The DCO has not satisfactorily addressed the following:

DRAWING TITLE
Project Wastewater Infrastructure

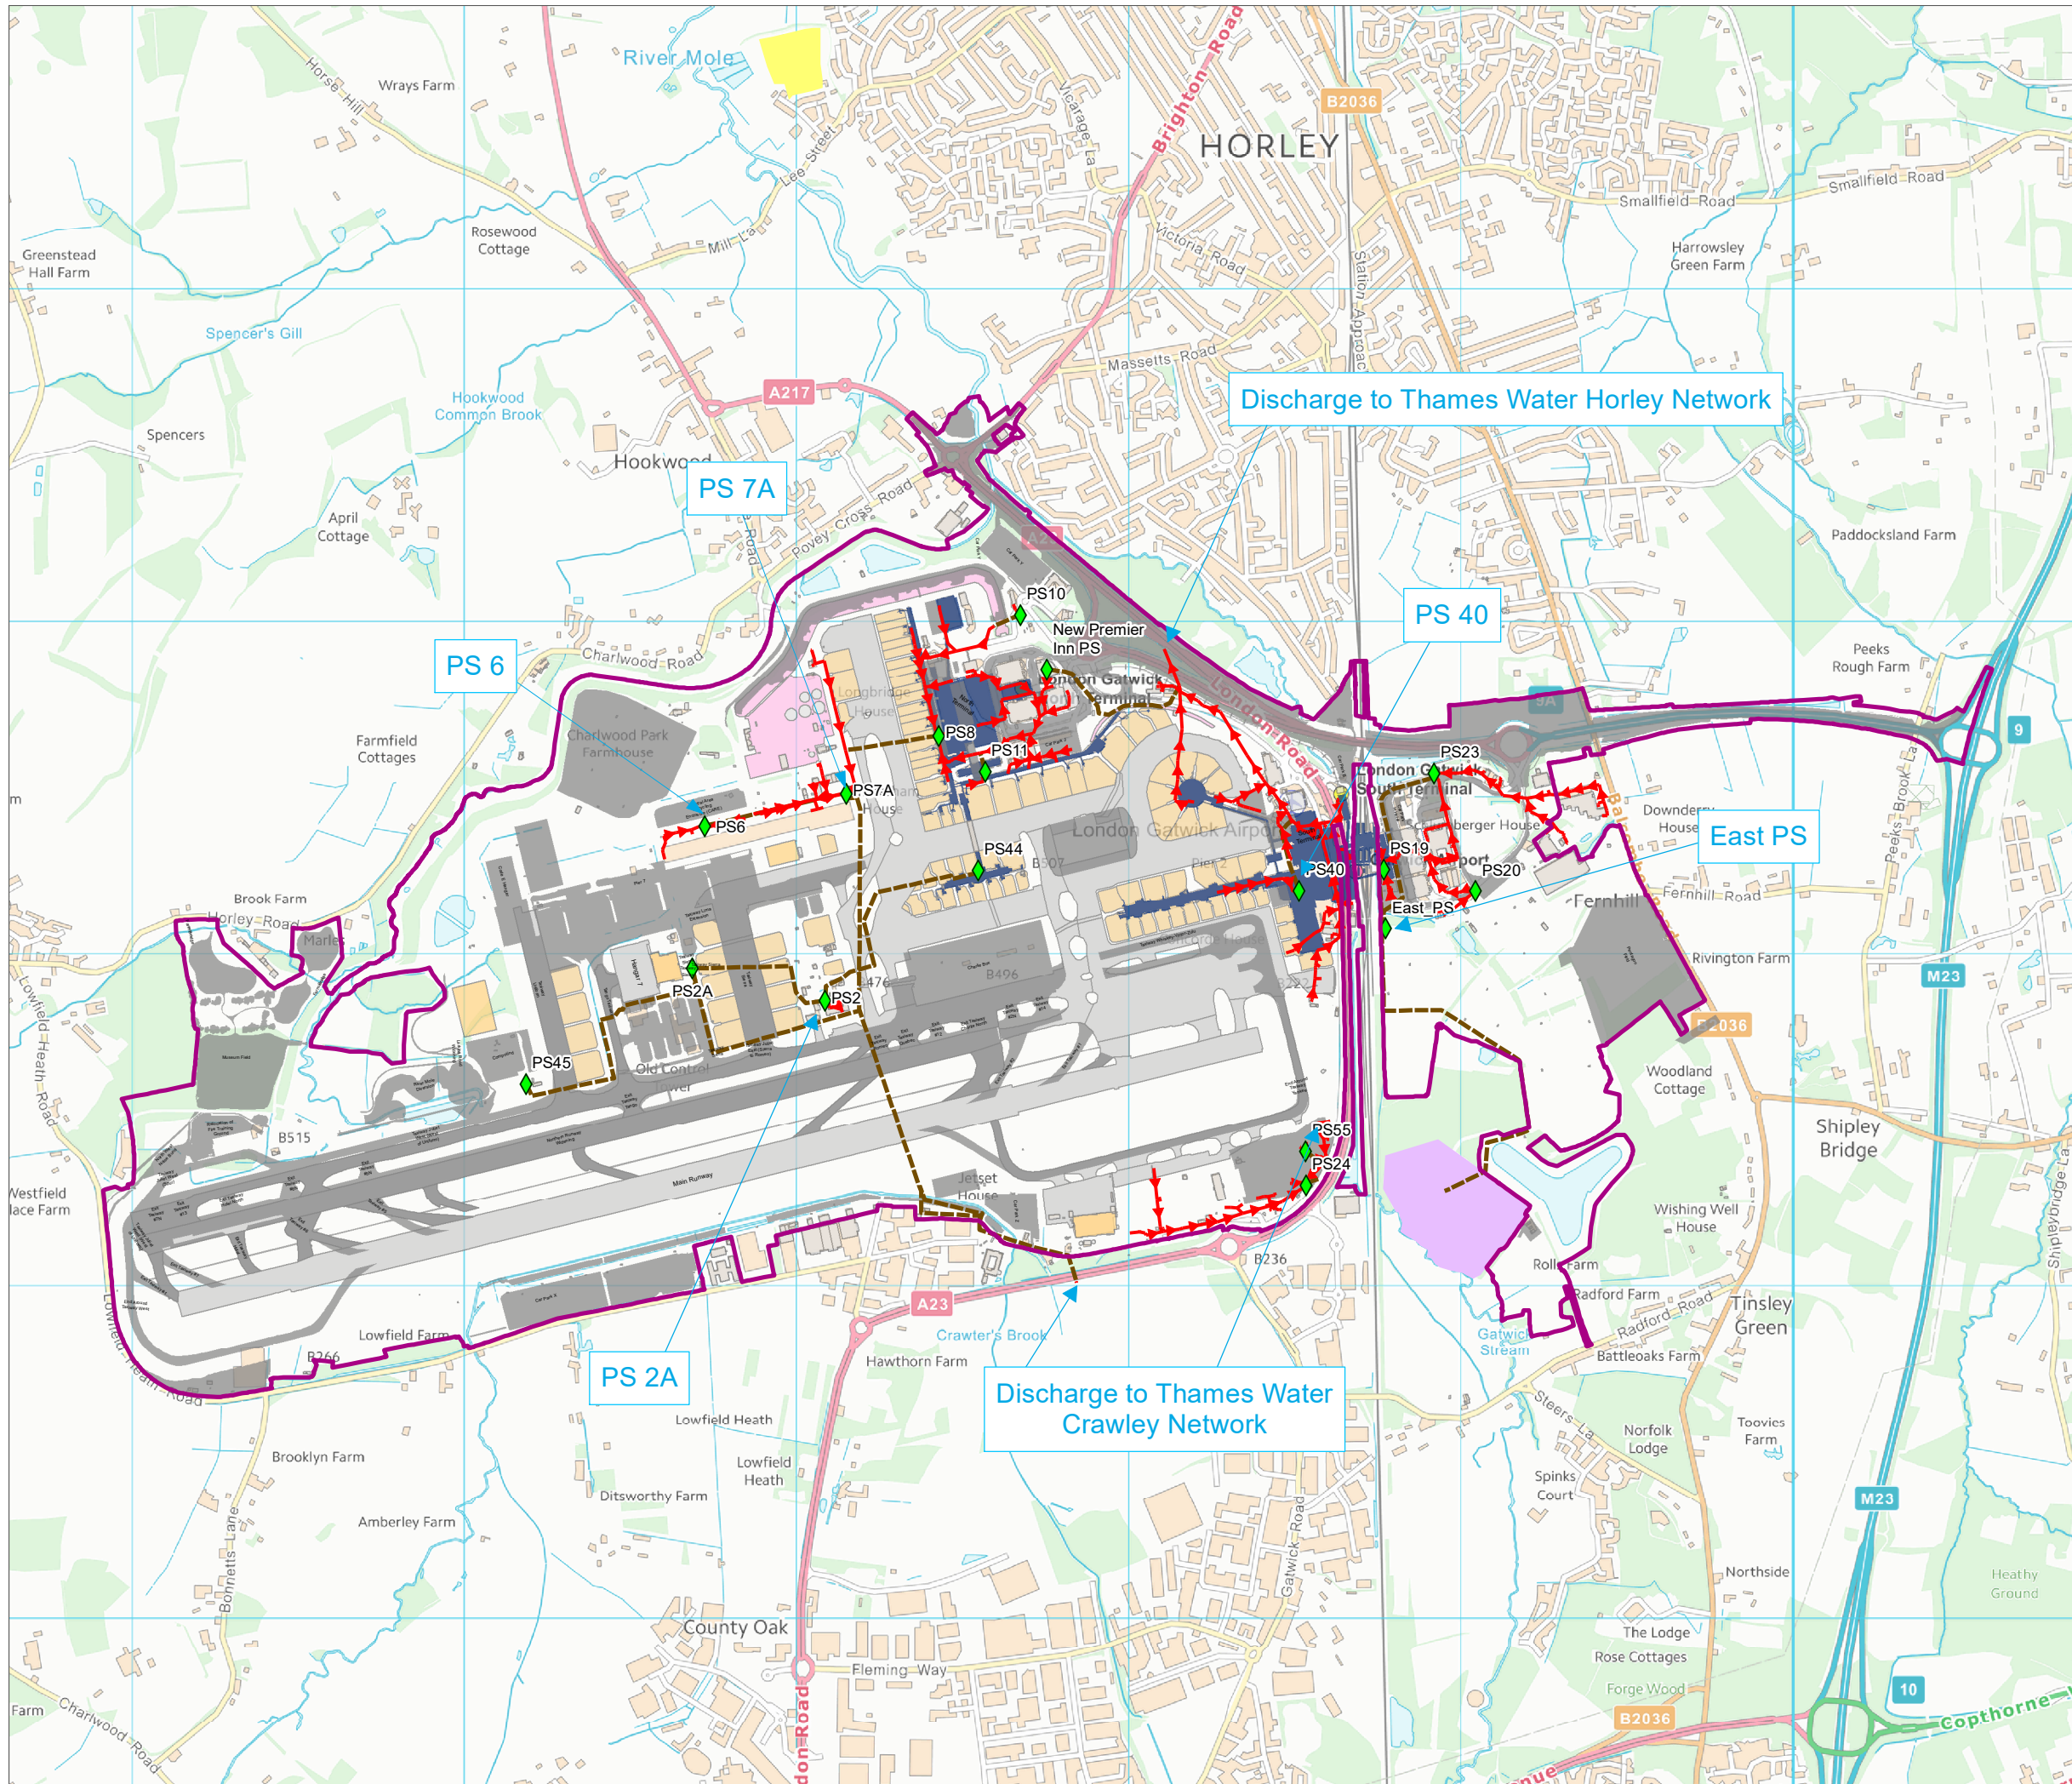
WASTE WATER flooding. As Thames Water have made no provision, The DCO must include a mandatory onsite waste water sewerage treatment plant to prevent local homes and environment being flooded with sewage.
